Application no: H14/0777/00

Description: Extension to form first floor office space

Amendment: Amended design
Site location and elevational plans

**EXTENSION TO FORM FIRST FLOOR OFFICE SPACE
MILL GREEN ROAD PINCHBECK SPALDING**

| DRAWING  | Proposed Floor Plans & Elevations     | SCALE 1:100 1:50 | DATE May 2000 804 20 |

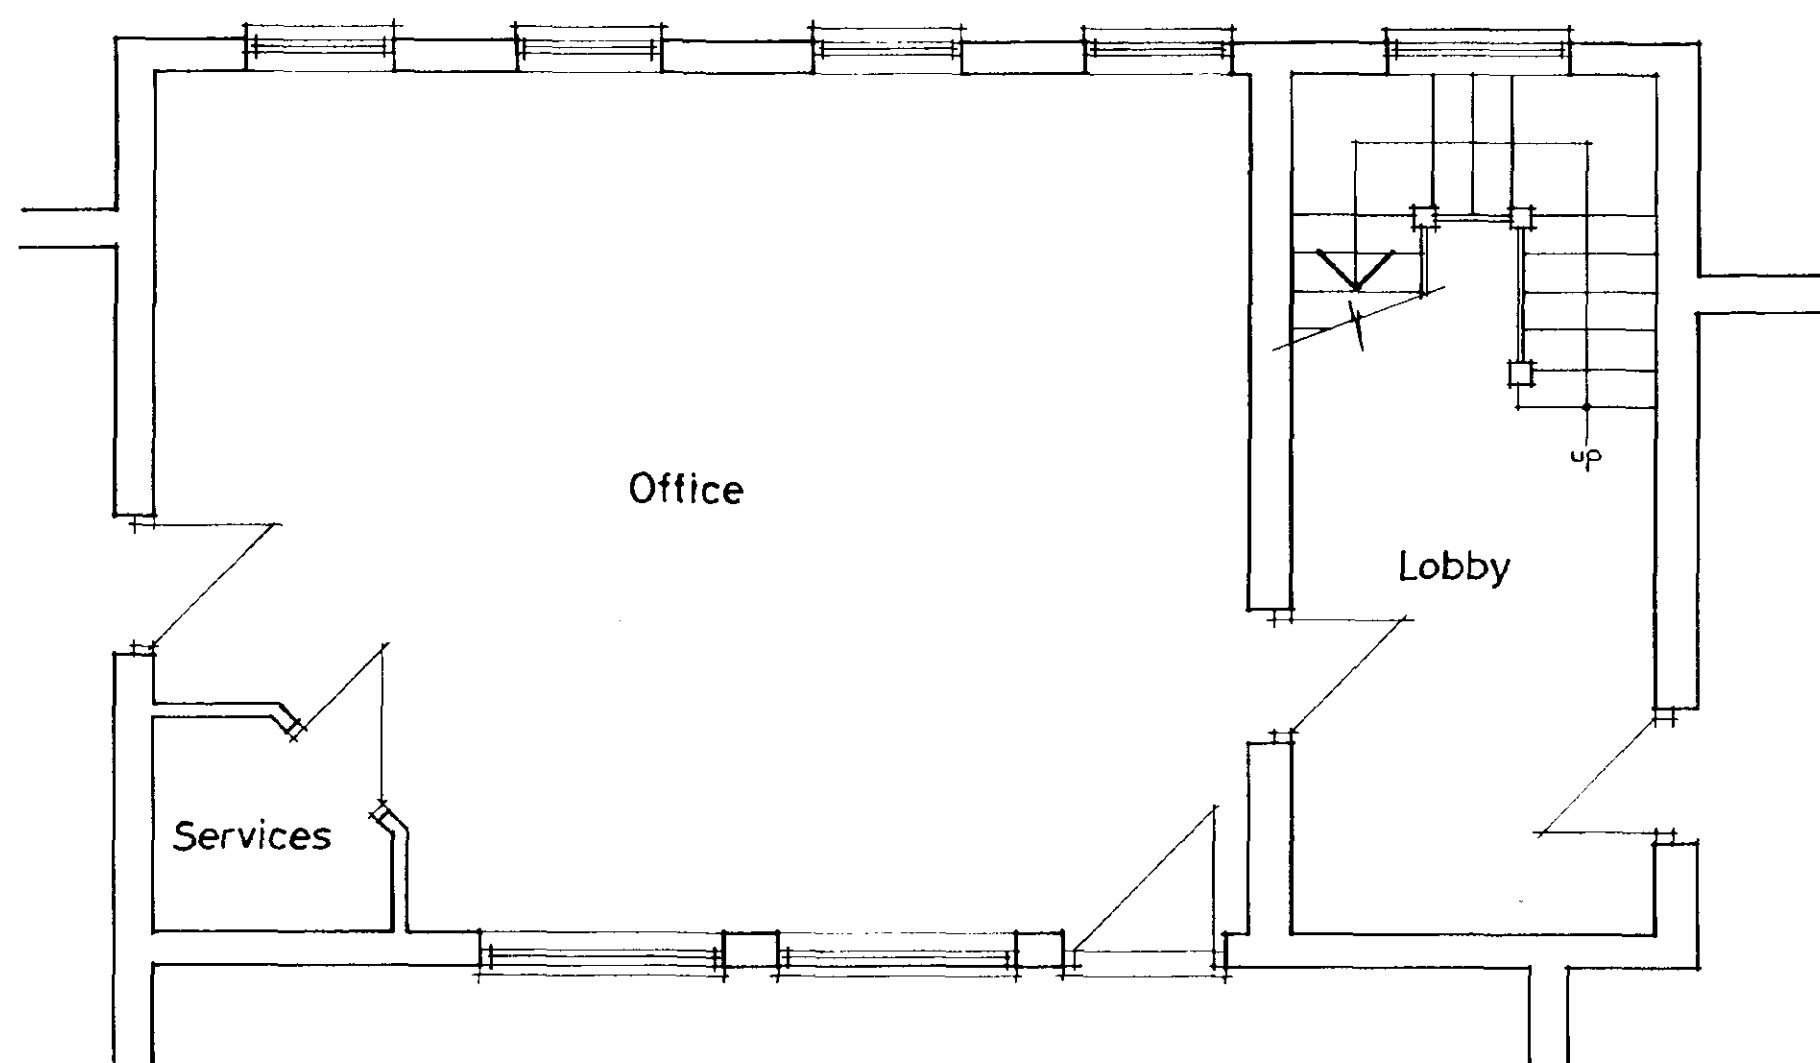
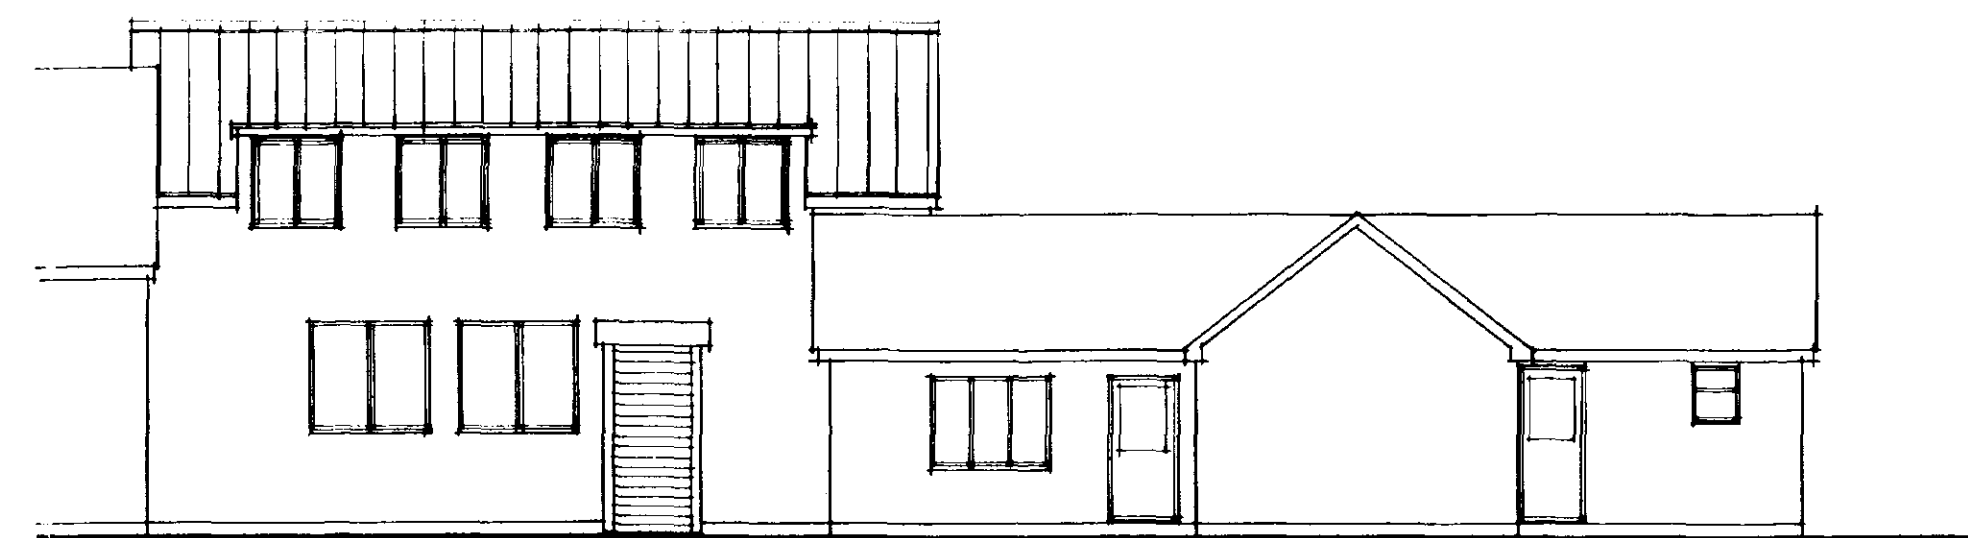
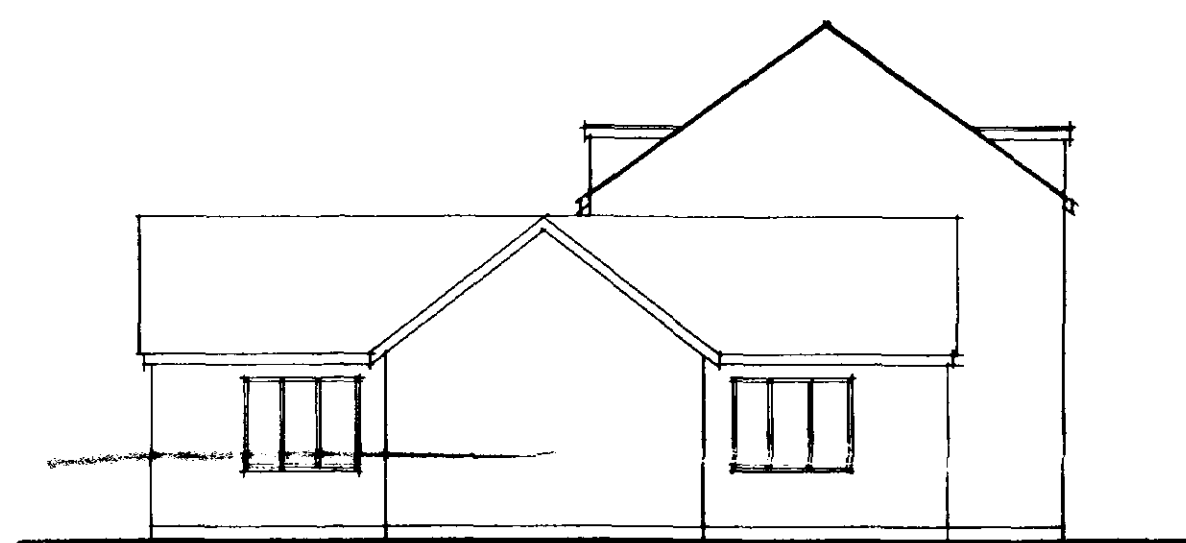
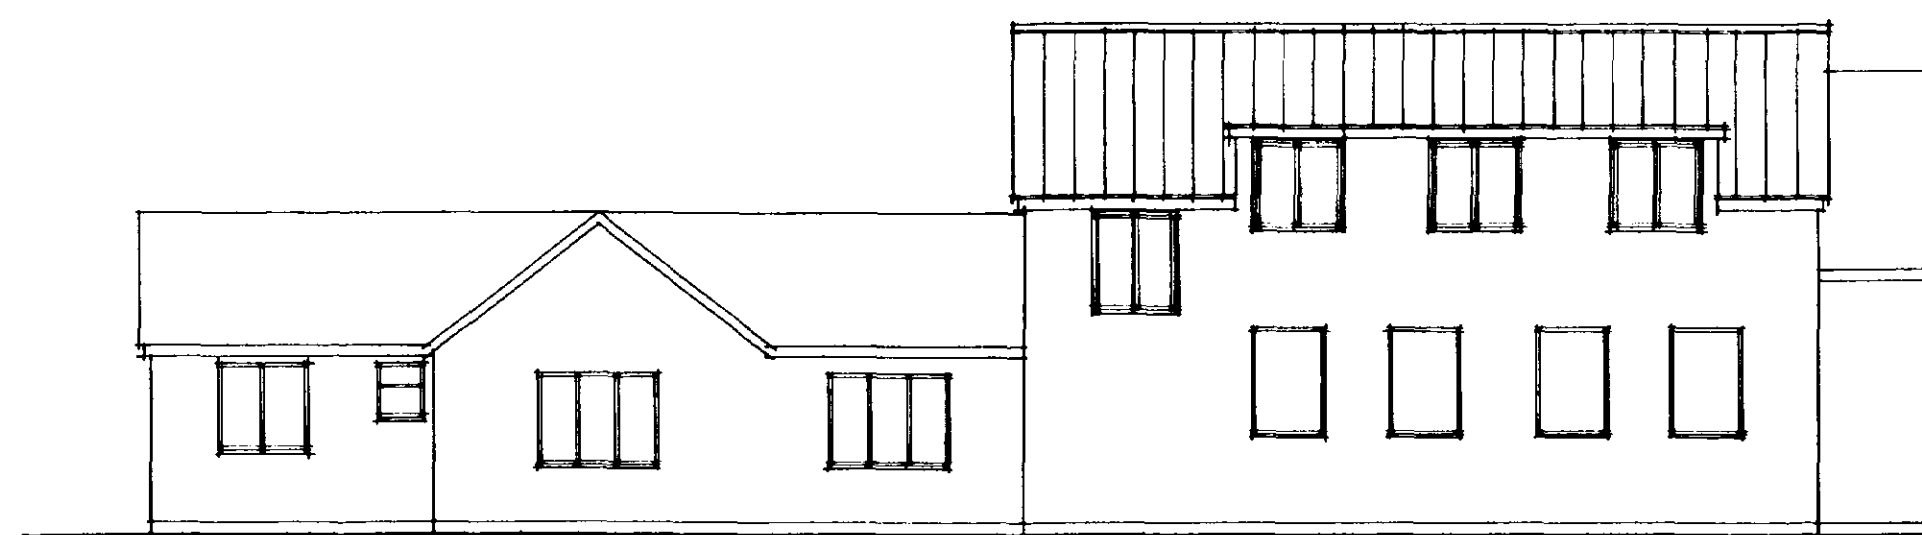
Please find enclosed herewith a drawing showing an amendment to the design approved on 4 August 2000 in respect of Application No. H14/0777/00. The original scheme was to insert a long dormer on each roof slope of the existing roof. This has now been changed so as to bring the eaves up to the top of the window heads on each side. The roof covering was to be in grey profiled steel, but the amendment would allow for the use of Redland Regent pantile profiled tiles to be used to give a traditional appearance.
